Application ref: A/67/26/DOC

Description: Approval of details reserved by condition under A/129/21/PL (Appeal ref: APP/C3810/W/22/3298192) relating to condition 7- Public Open Space and Play Areas.

Location: Rustington Golf Centre Golfers Lane Angmering BN16 4NB

Summary recommendation: Recommend to Discharge Condition 7 under this application A/67/26/DOC - details of Public Open Space and Play Areas.

DRAWING NO: Q7619_H

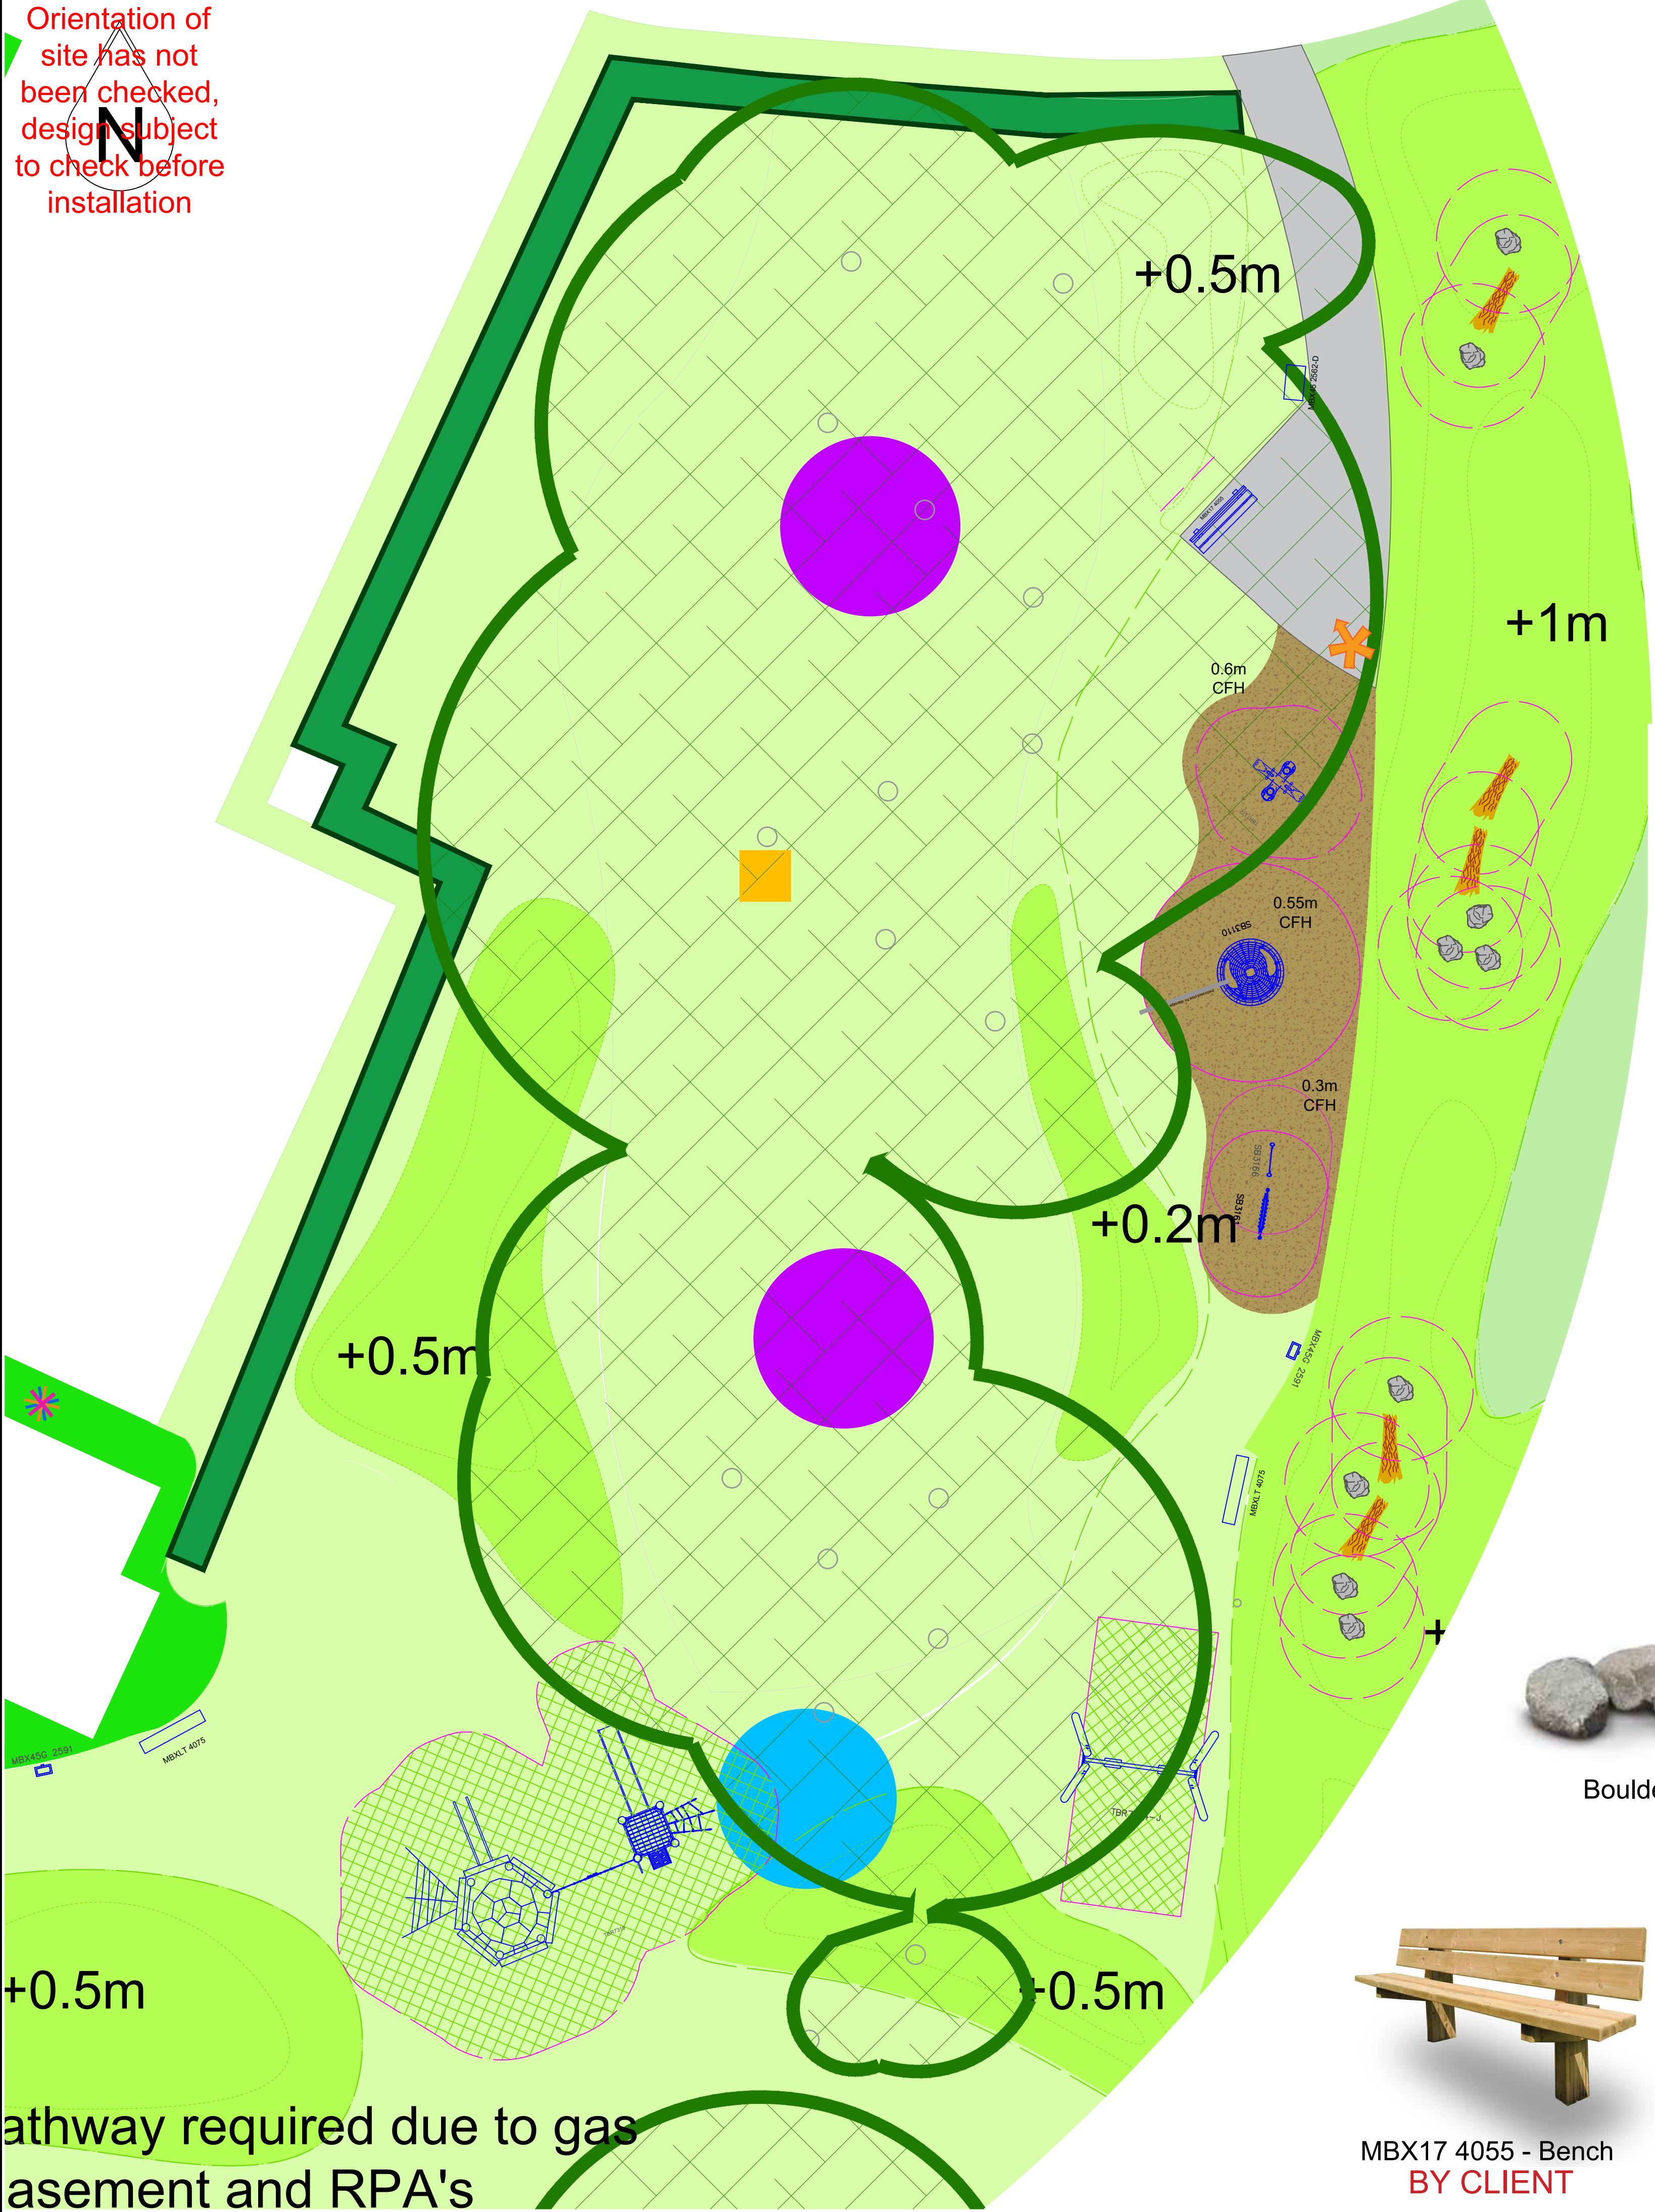
Planning Condition 7 was discharged by ADC on 19 March 2025 under planning reference A/30/25/DOC. The information under this A/67/26/DOC application seeks to supersede the designs for the Southern LEAP following consultation re conflict with the retained woodland area dig strategy. The resulting change is for the location of the Roundabout and Springer Seesaw to switch locations to avoid conflict which is a sensible and supported solution.

Detail has been submitted within Dwg Q7619-H-Rustington South LEAP Plan – No objection to the superseded proposals.
